Submission for
State Significant Development – Pymble Ladies College - Grey House
Precinct

Application Number SSD-17424905

I live in Pymble Ave and I **object** to the Grey House Precinct project.

NORTH / SOUTH ELEVATION

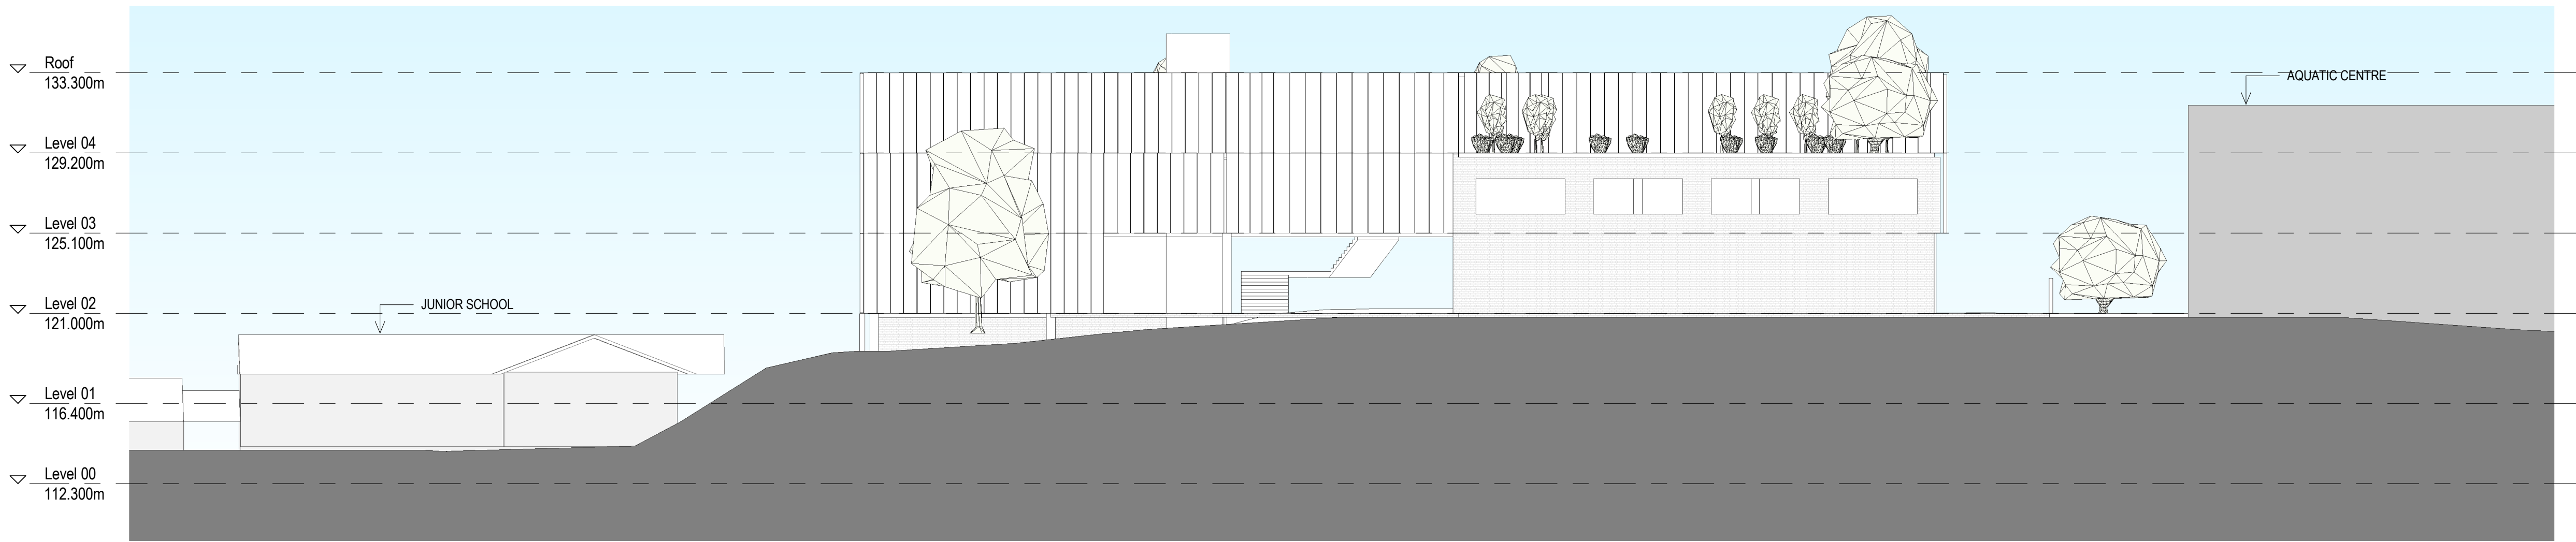
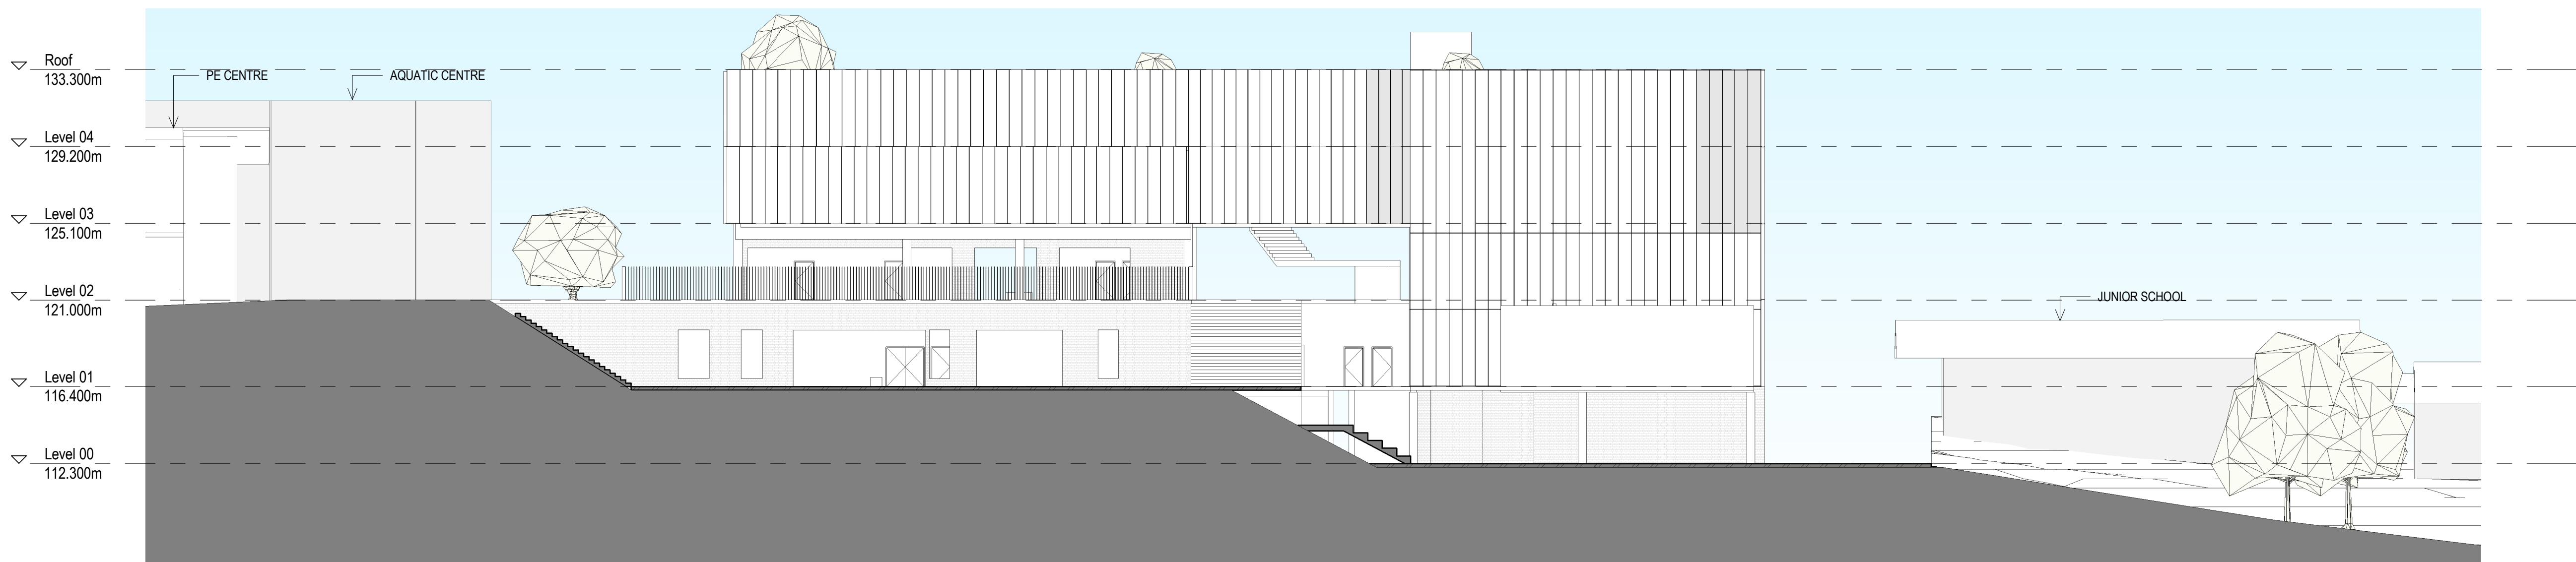
Pymble Ave Heritage Conservation Area (HCA) hosts several heritage significance buildings for the culture and history of Pymble. The look of the Grey House Precinct (GHP) from Pymble Ave within the HCA does not fit into the local context and characters. Furthermore, the height and mass of the building is an eye sore to the residents and visitors of the area.
